100 Nine Design Limited

25th November 2021

RE PROJECT :- 238/21 PROPOSED BARN CONVERSION

Scale. 1:100	Drawn. LB	Checked. NC	Date. Nov '21
Drawing No. 8454-03-04	Revision.

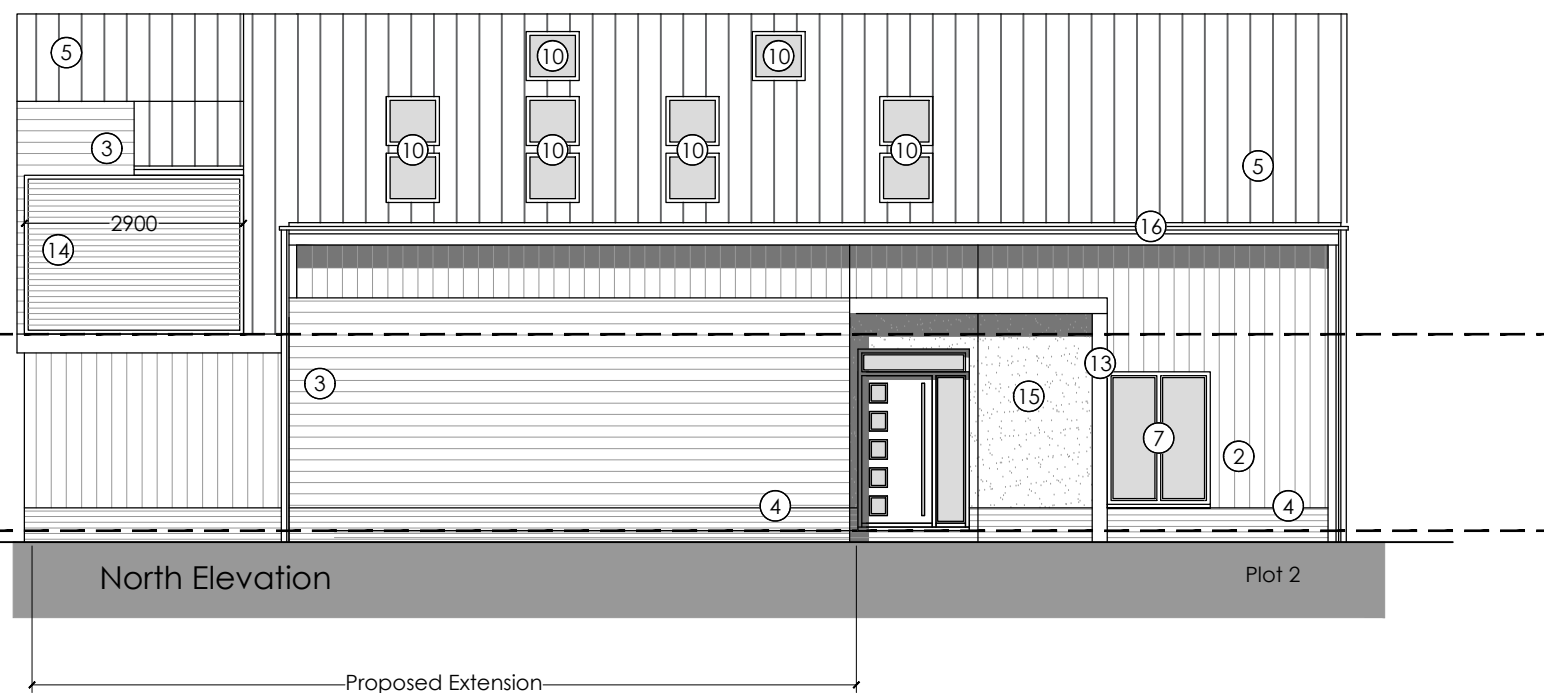
It is noted that the current proposal includes for a roof covering of "Profiled Sheet Steel/Zinc Insulated Roof Sheeting", we have assessed this type of construction to have a weight in the order of 0.115 Kn/m^2 .

The existing roof covering to which our previous report stated is "Asbestos Cement", which we consider to weigh some 0.150 Kn/m^2 – which is heavier than the proposed and we therefore state this type of roof covering in lieu of the existing is consider acceptable

However, if the Asbestos Sheeting is to remain and be over clad with the proposed Metal sheets, we again refer to our report (dated 11/11/21) and note that the effect of such over cladding would increase the overall roof loading by some 14%.

Inspection of our previously presented calculations concludes that this extra loading can be safely applied, without any detrimental effect on the proposals.

Scale: 1:100	Drawn: LB	Checked: NC	Date: Nov '21
Drawing No. 8454-03-03	Revision:

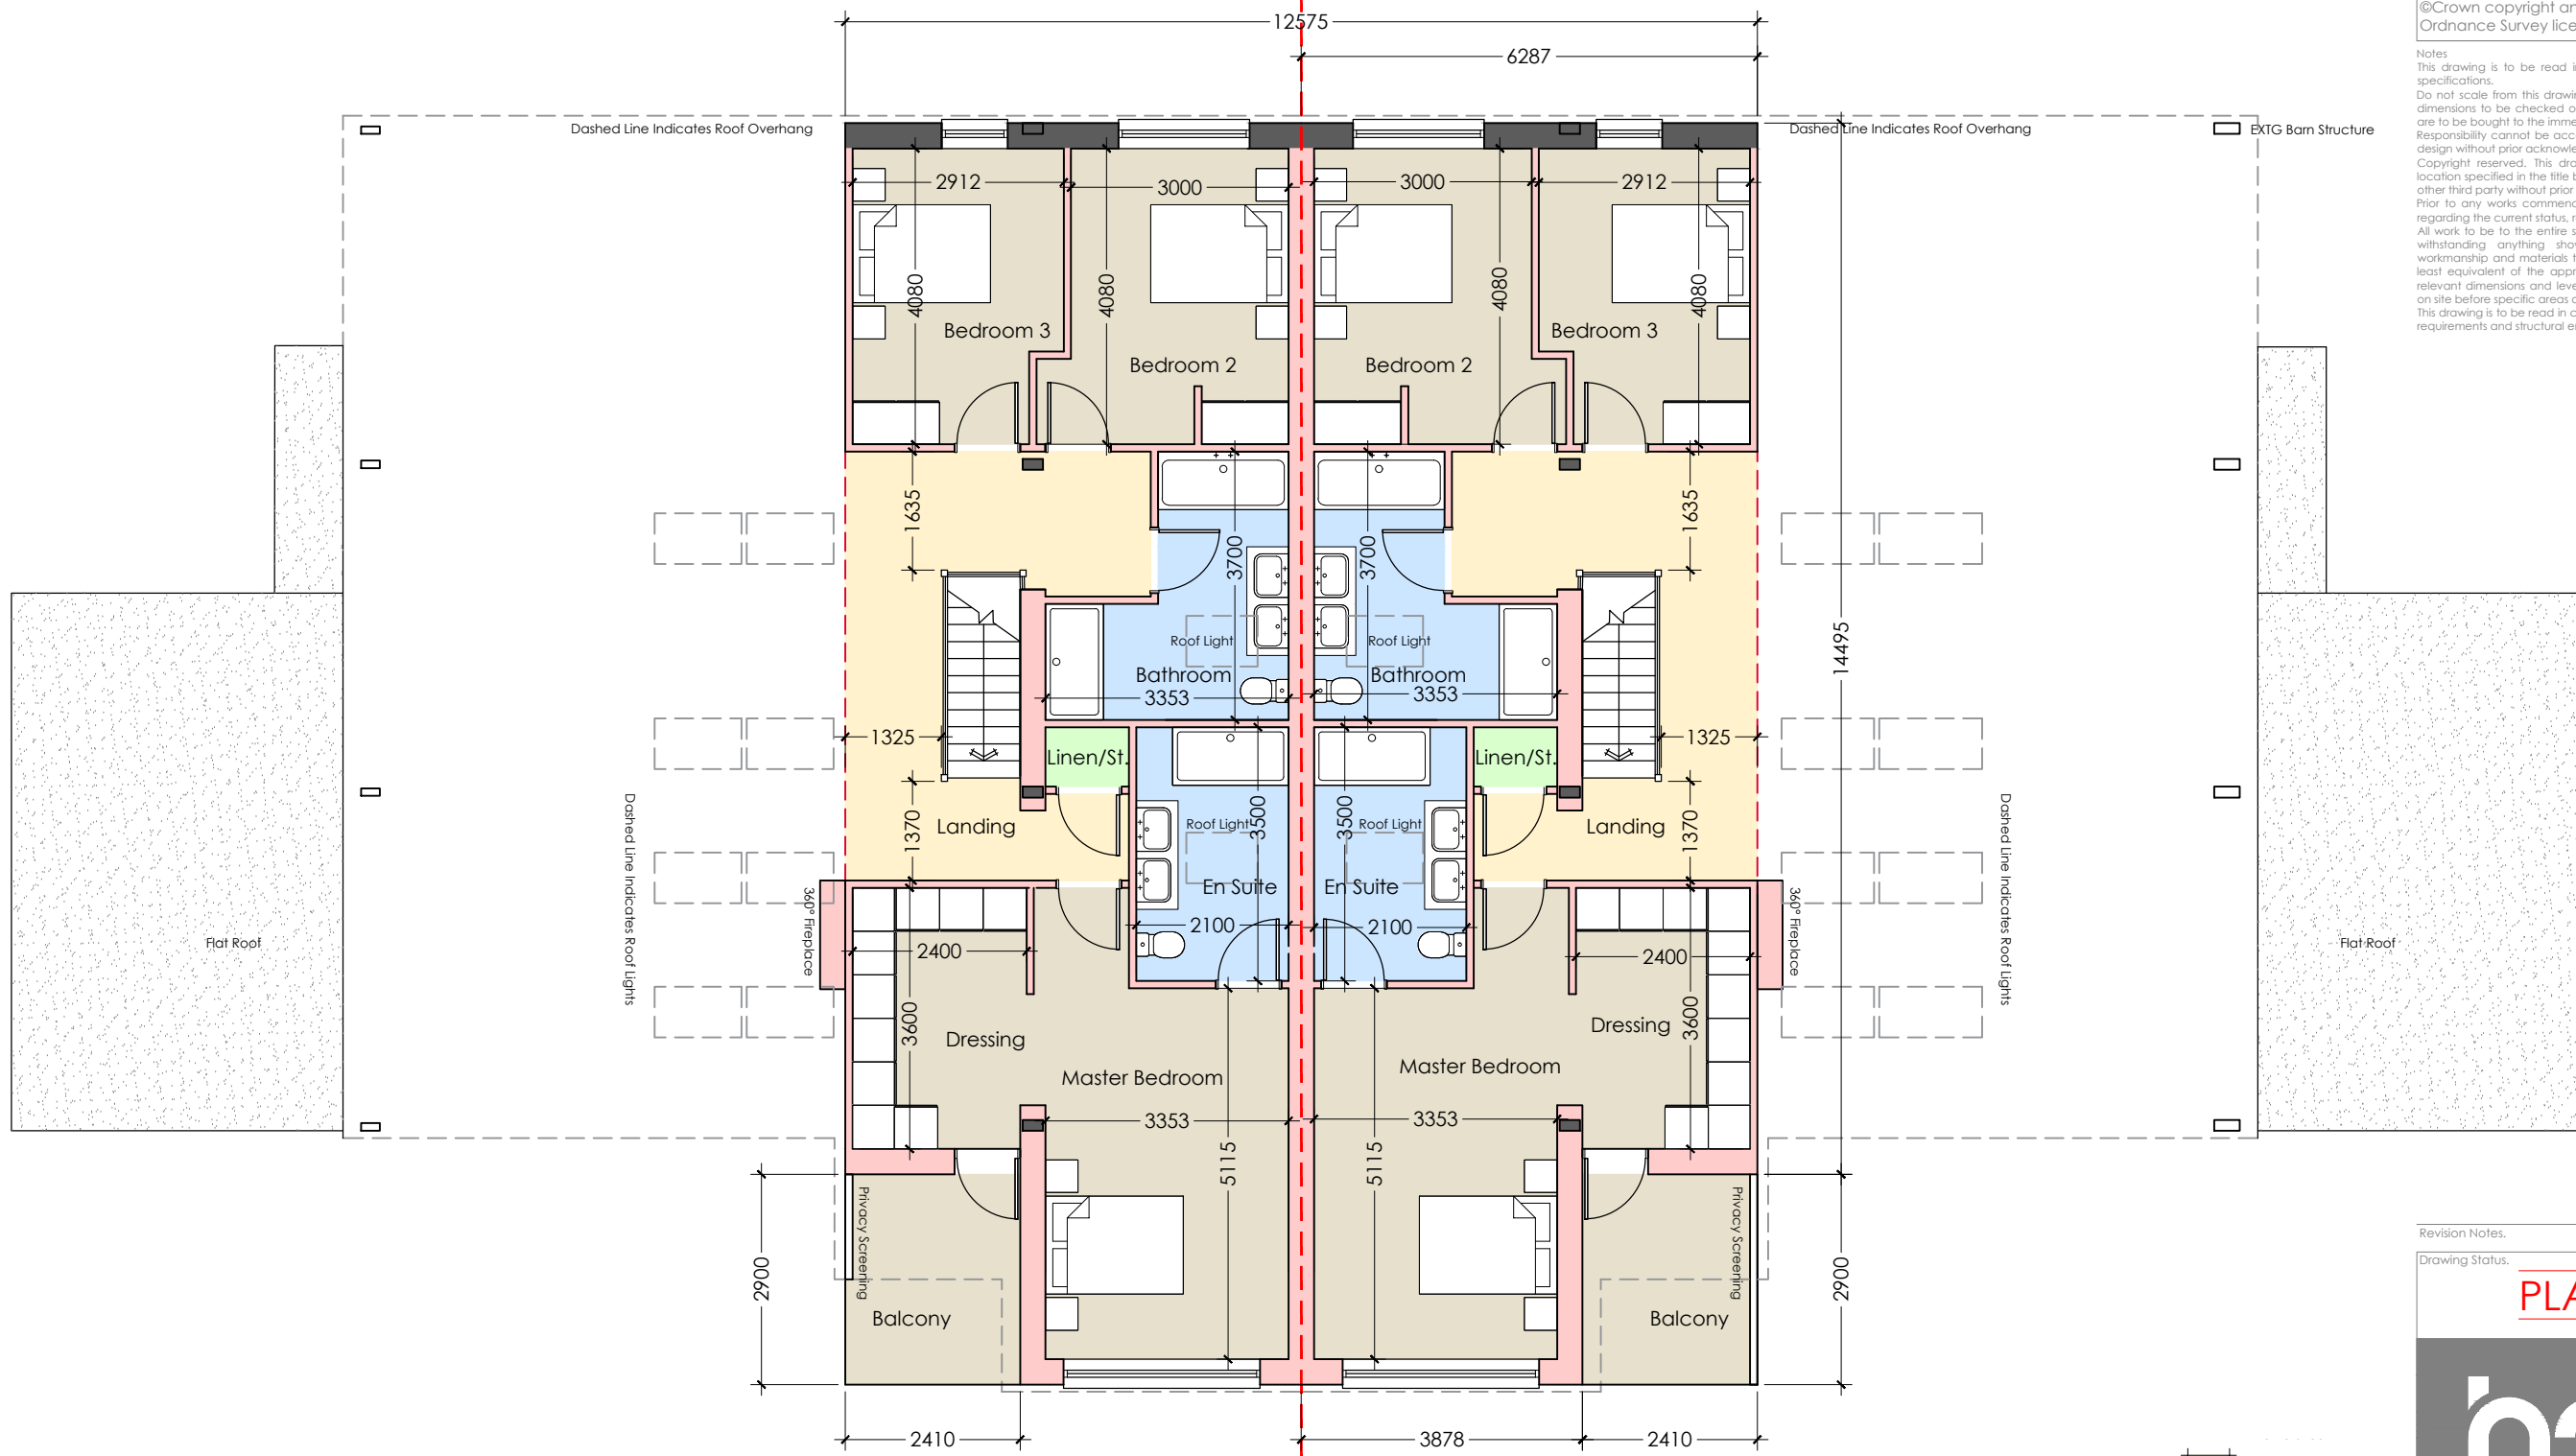
Examination of the architect's drawings indicates the separating of the internal space with a division/party wall, we have assessed this using the following applied loadings:-

Ceilings ---Dead @ 0.25 Kn/m^2
Ceilings ---Super @ 0.25 Kn/m^2
Walling ---Dead @ 3.50 Kn/m^2
Flooring---Dead @ 1.50 Kn/m^2
Flooring---Super@ 1.25 Kn/m^2

Summing the above and multiplying by the relevant areas gives a load of 39.85 Kn/m Run

We have stated the existing slab is of a good and consistent quality, hence assuming it is of a nominal 150mm thick unreinforced concrete with a minimum of 150mm hardcore sub-grade, this provides a spread onto the underlying ground of some 1035mm, which equates to a Applied Ground Pressure beneath the wall of some 38.5 Kn/m^2 .

The foundation checks and visual assessment of the existing ground (viewed via a trial pit excavation) showed adequacy with a maximum permitted Safe Bearing Pressure of 110 Kn/m^2 , hence we consider that building the proposed party wall off the existing is satisfactory.
